***Garvan St Vincent's Campus Cancer Centre,
Darlinghurst***

***MP 09_0011 MOD 1 – Modifications to
building alignment; northern façade signage
and ground floor tenancy use***

Director-General's
Environmental Assessment Report
Section 75W of the
Environmental Planning and Assessment Act 1979

November 2012

LEVEL 3

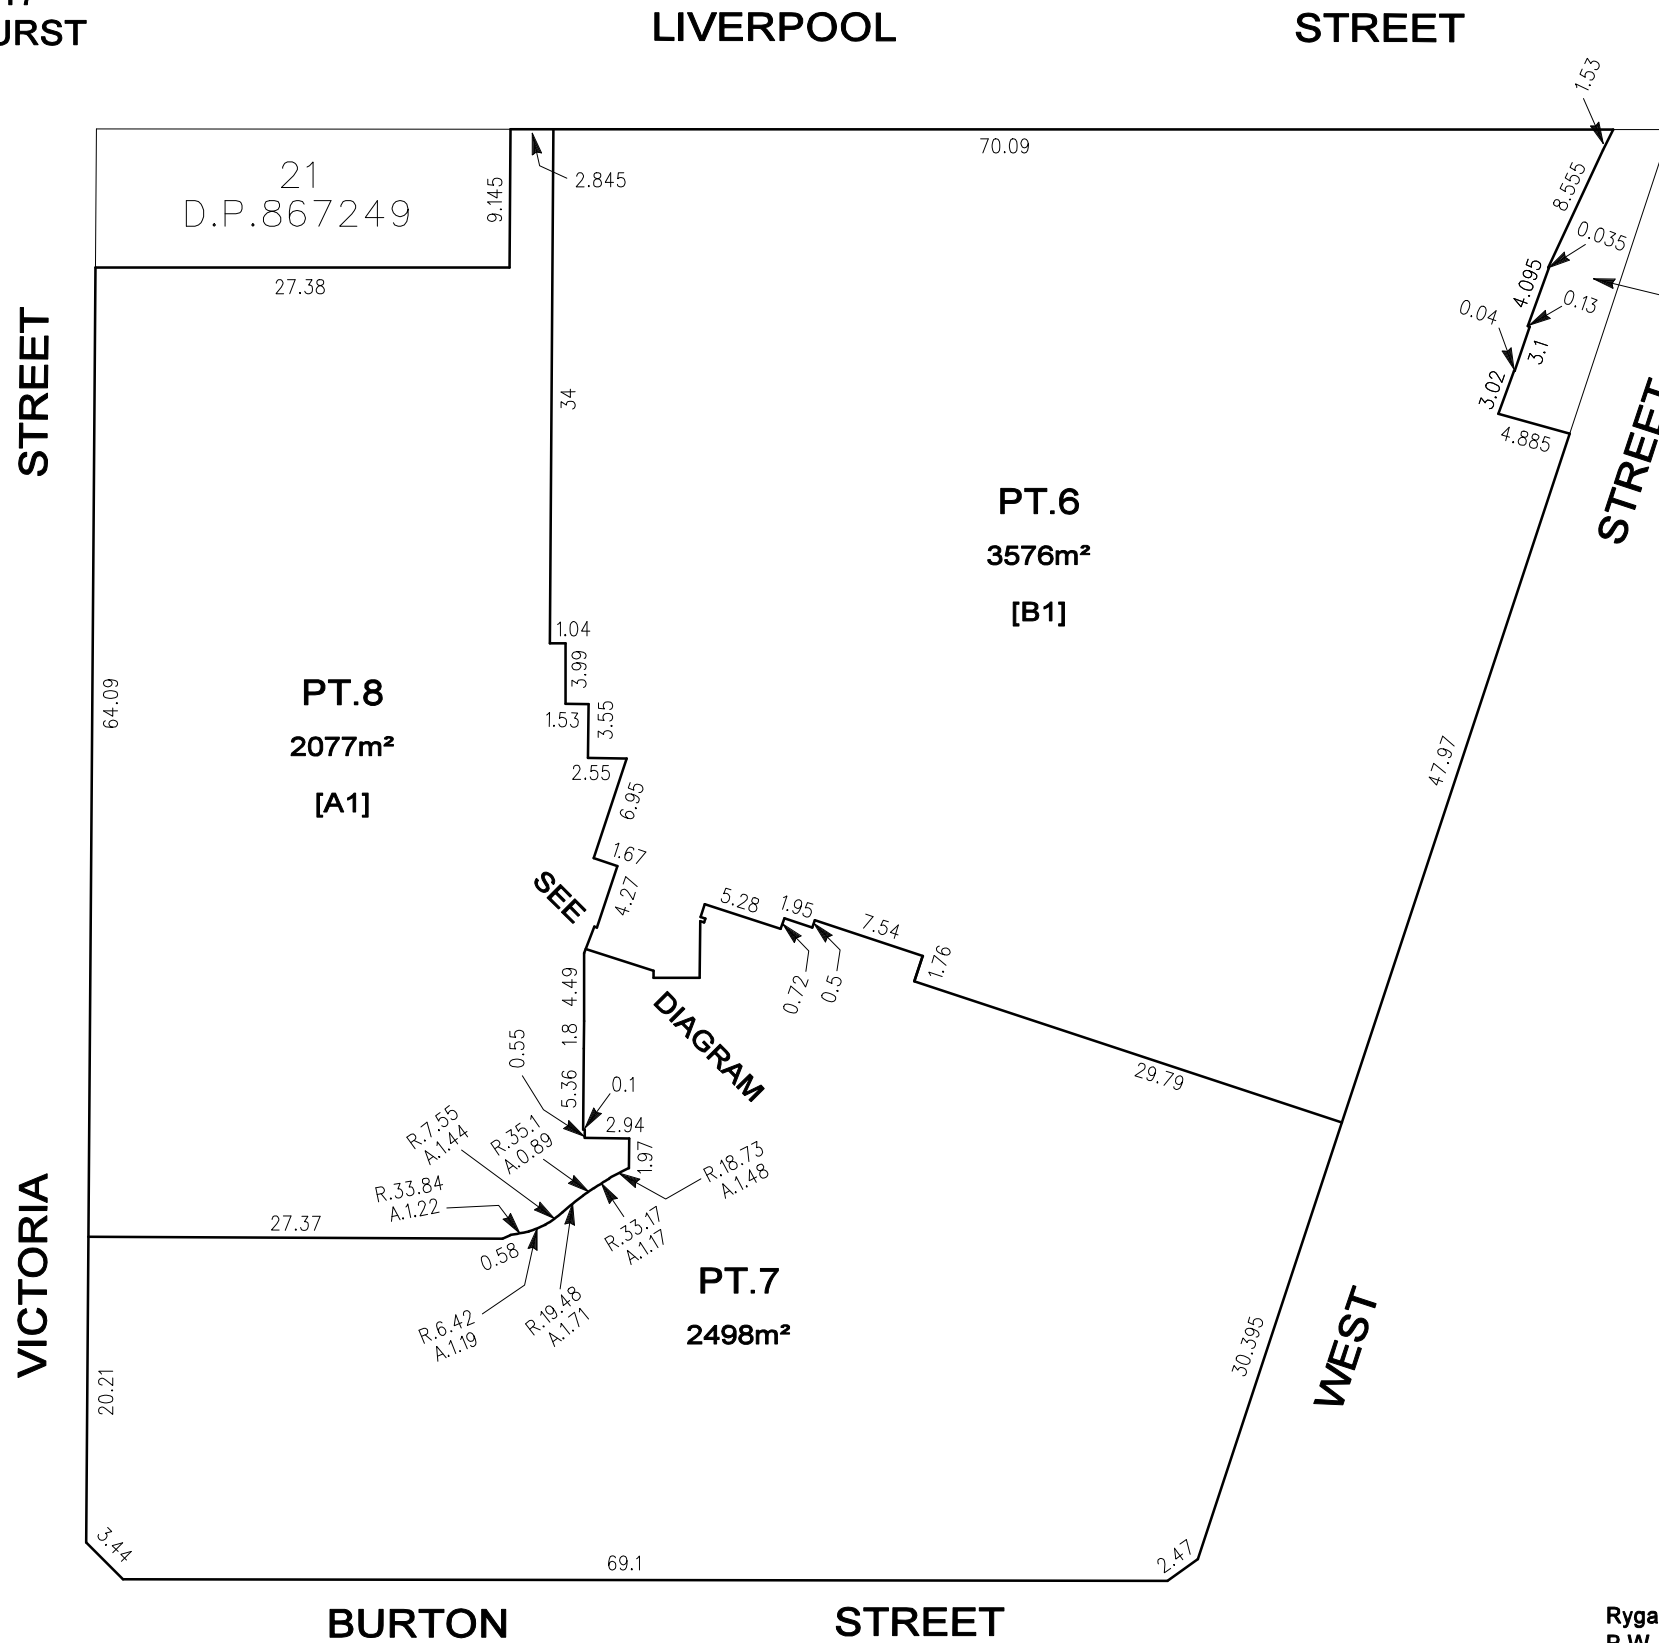
The proposal seeks to modify the boundary alignment by moving the boundary between lots PT8 and PT5 approximately 2.78 metres to the west on level 3-10 and amend the boundary between PT5, PT7 and PT8 to take account of services to the development. The proponent has indicated that the realignment will streamline the boundaries of the site.

Council raised no objection to the proposed boundary alignment, stating that the modification was minor in nature.

The Department is satisfied that the proposed boundary realignment will not produce adverse impacts for the development or the environment.

NEW FITOUT PLAN

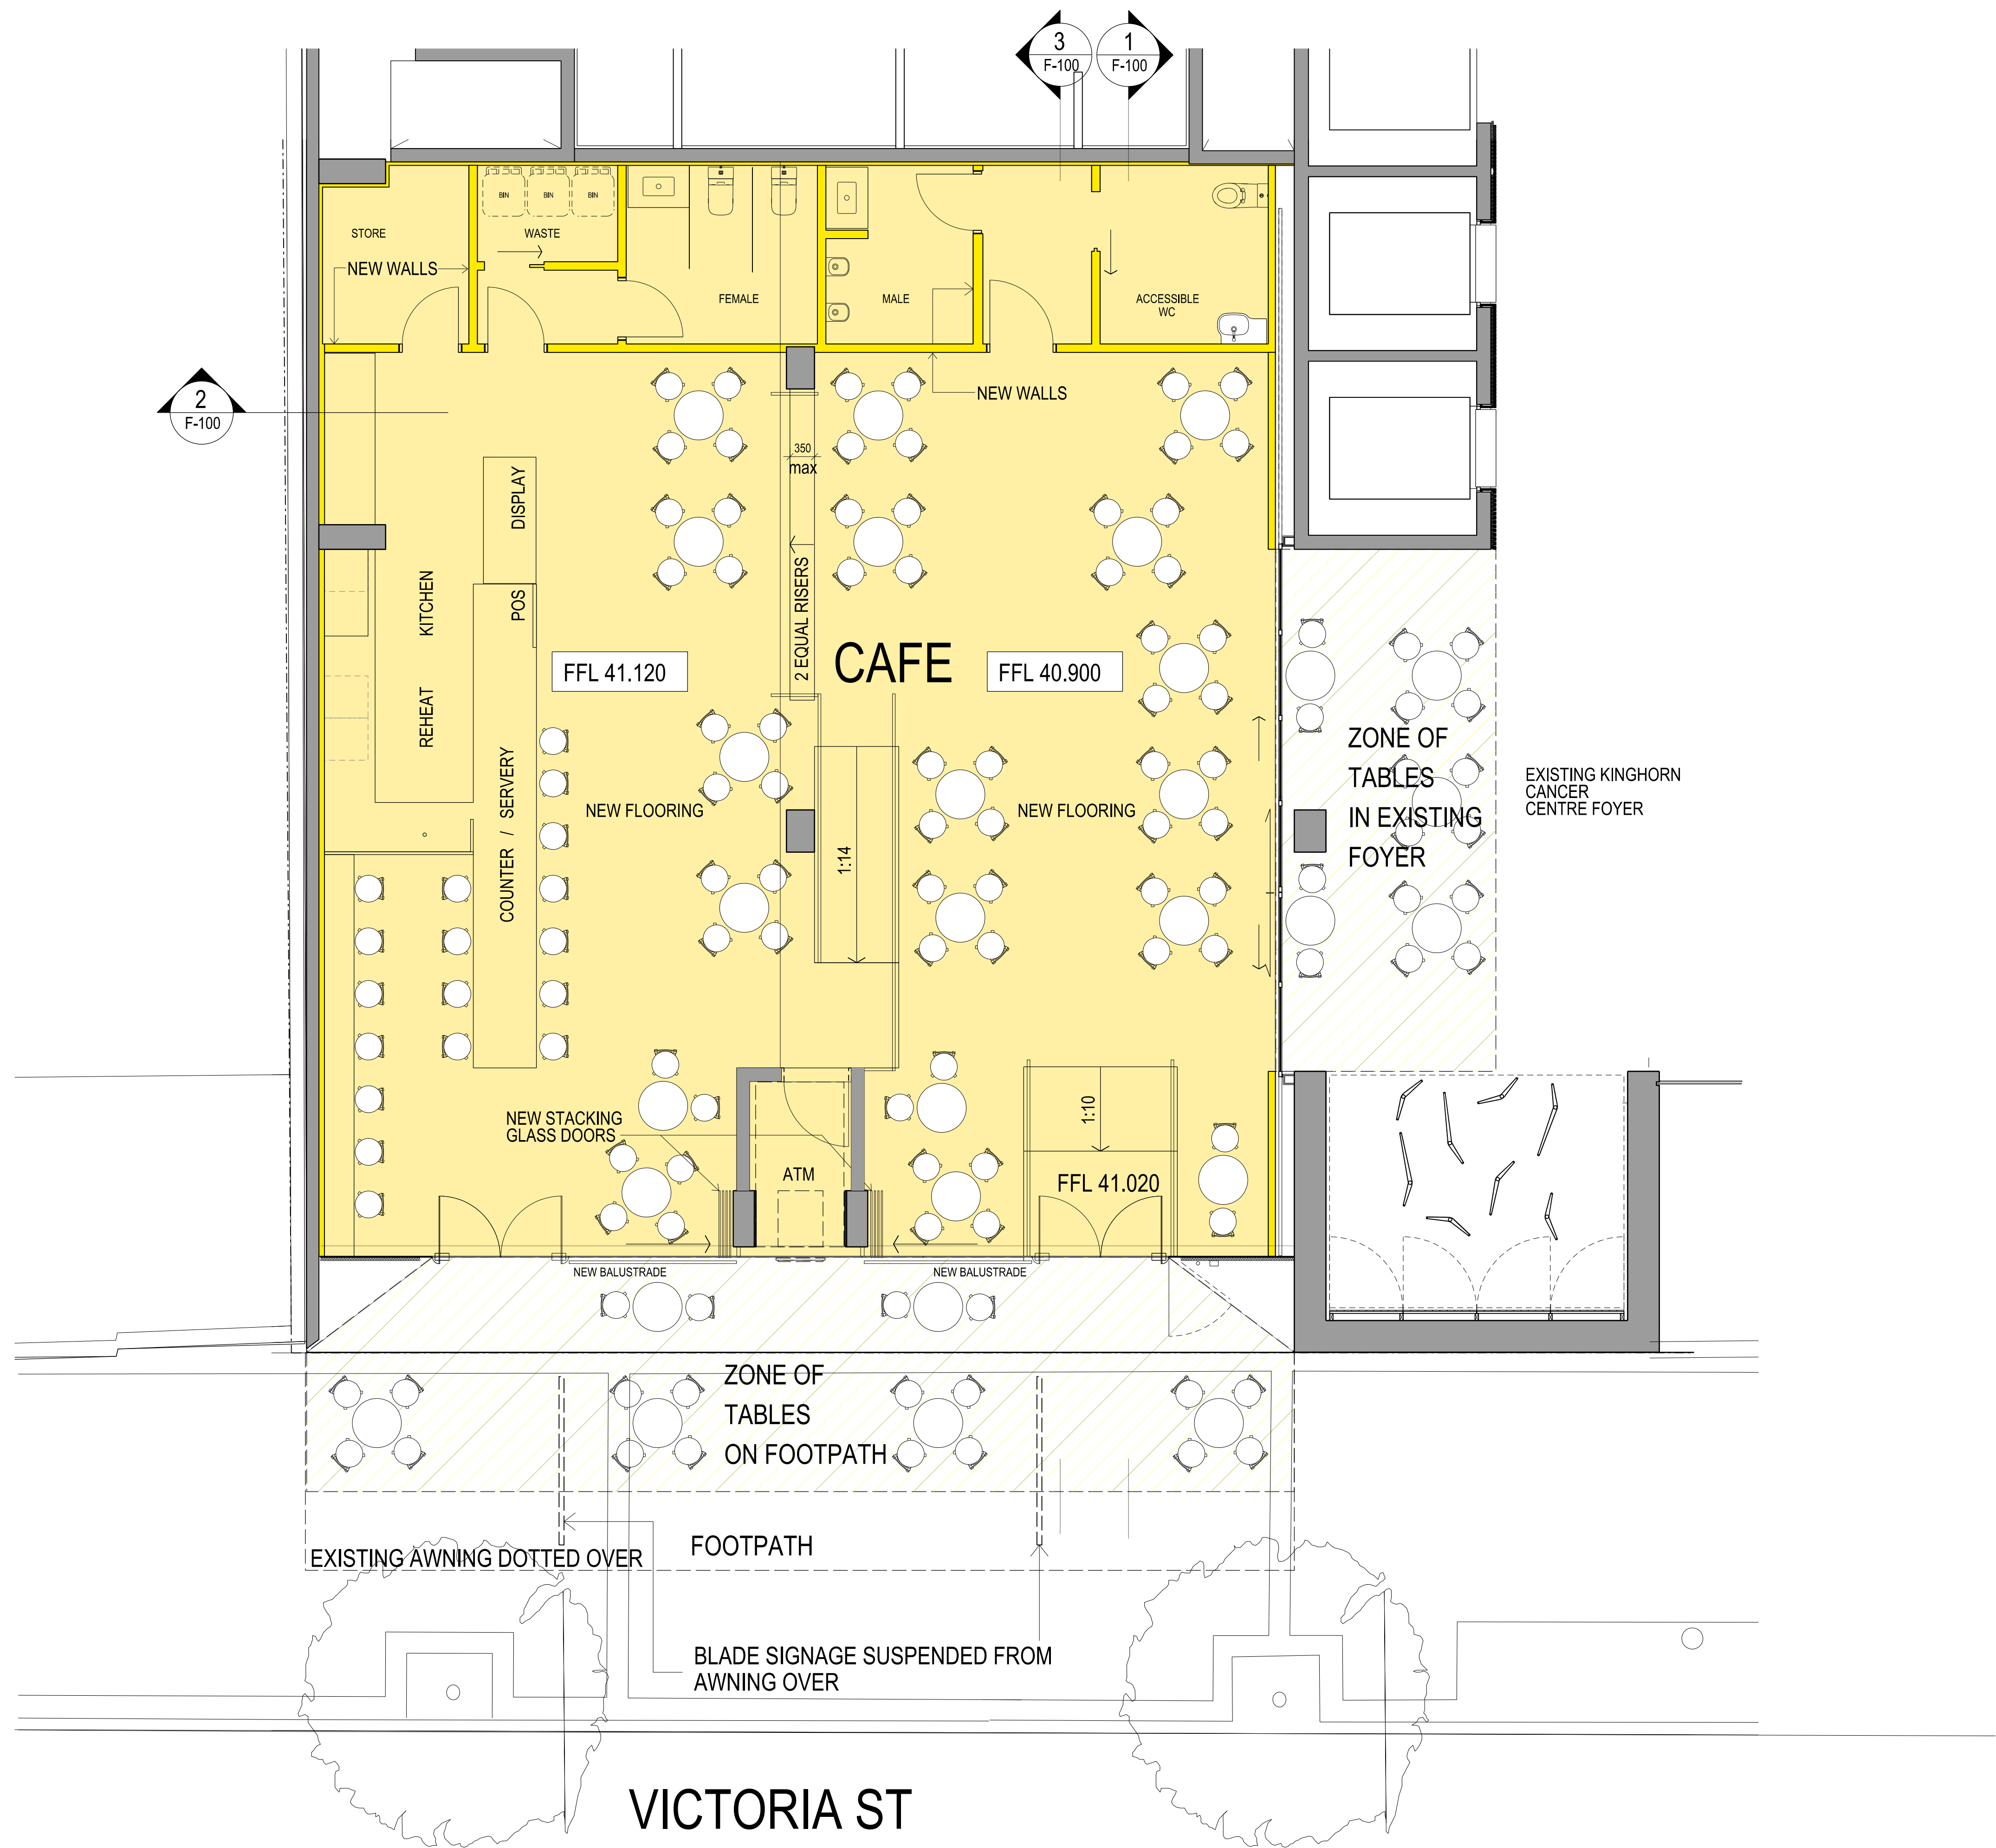
Council have recommended that measures be implemented to ensure the premise is used solely as a café and restrict any changes to this use. The proponent has indicated that the application is for a café, therefore the Department will assess the merits of this application based on this provision.

Council noted that the proposal does not provide for mechanical cooking exhaust, therefore no food should be cooked on site. The proponent indicated that food items sold on site will not be prepared at the premise.

Therefore, the Department is satisfied that the proposed use of the ground floor tenancy is consistent with the original project approval.

ELEVATION

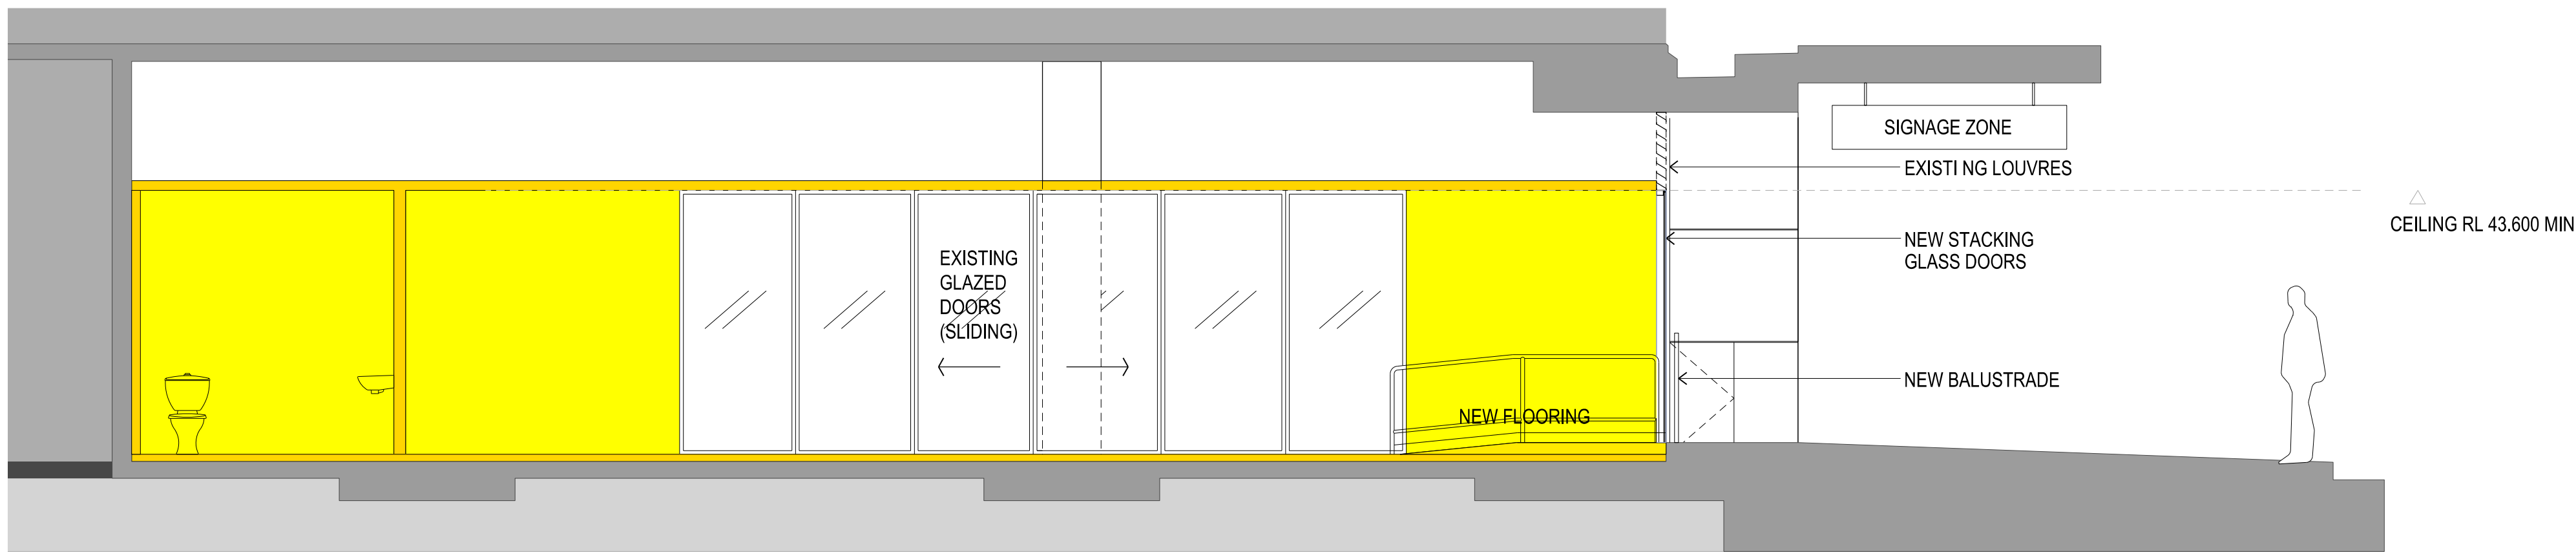
The modification also seeks to install folding doors at the tenancy entrance, as shown in **Figure 4**. Council raised concerns over the proposed glass sliding doors for the café and whether the noise generated from opening of the doors will impact on the local amenity. The proponent revealed that many uses along Victoria Street operate with their doors open to allow for street activation. The proponent has also acknowledged that doors are not to remain open after 10pm Monday to Sunday. The café will not generate unacceptable acoustic impacts on the locality, particularly when viewed in context with the surrounding late night trading establishments.

On this basis, the Department considers that the proposed modification will not produce adverse impacts on amenity given that:

- the premise is located in close proximity to other late night uses;
- extended trading hours are subject to a 1 year trial period to allow for ongoing monitoring; and
- the opening and closing of doors is consistent with the objectives of City of Sydney's Late Night Development Control Plan.
